WILPSHIRE PARISH COUNCIL

3/2012/0390 Land between 52 & 54 Knowsley Road, Wilpshire

3/2012/0401 51 & 53 Knowsley Road, Wilpshire – outline application

Drawing Title: Proposed Elevations and Section

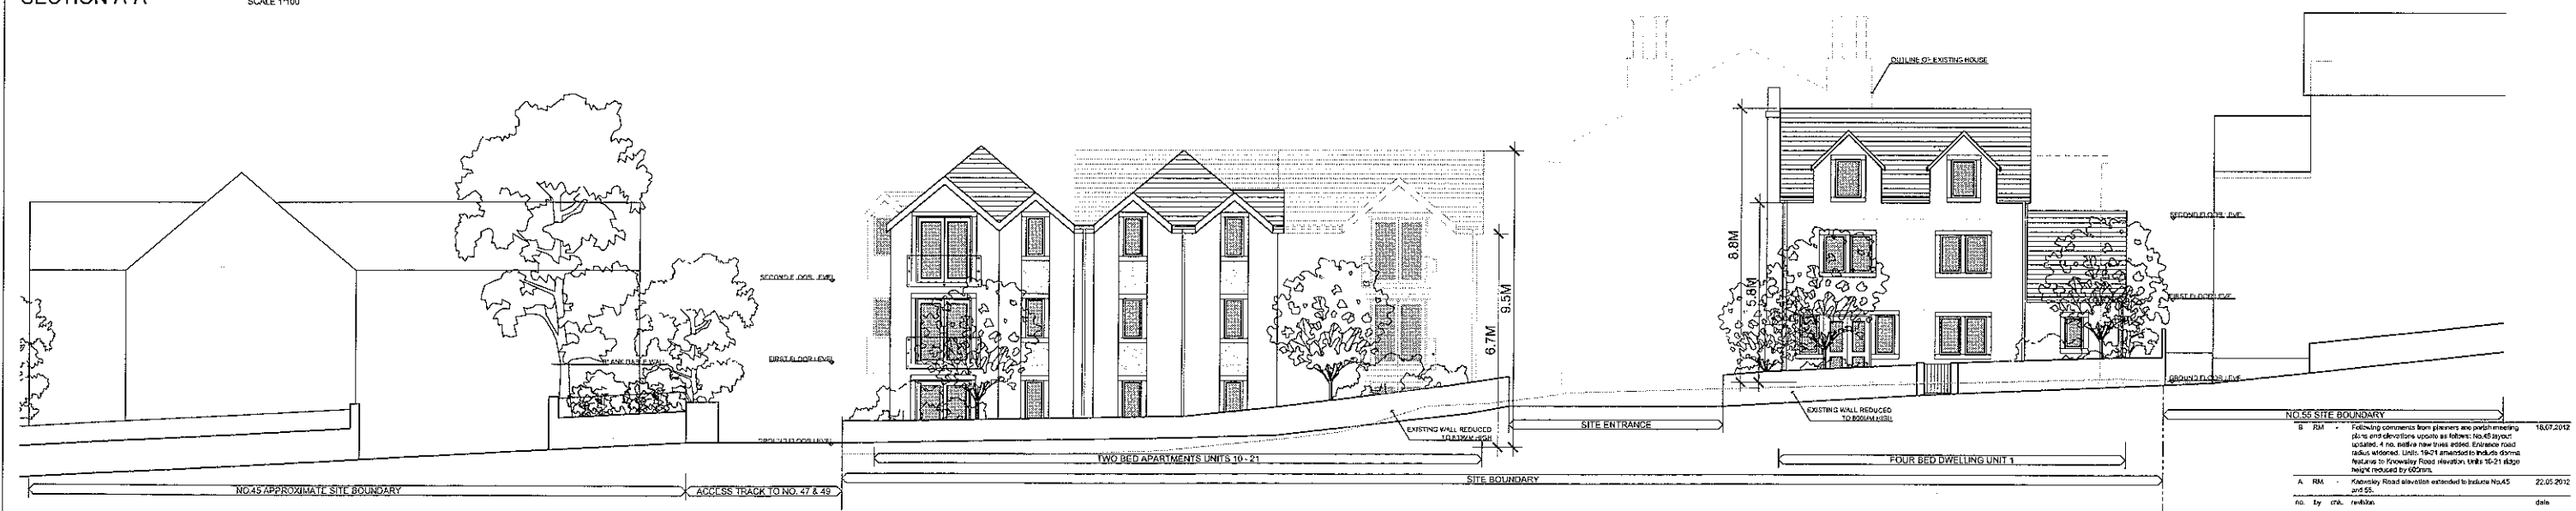
Wilpshire Parish Council object to the above application for the following reasons:

3 storey development is out of character in Wilpshire
inappropriate development for the site
over development of the site
increased volume of traffic onto Knowsley Road
Parking issues.
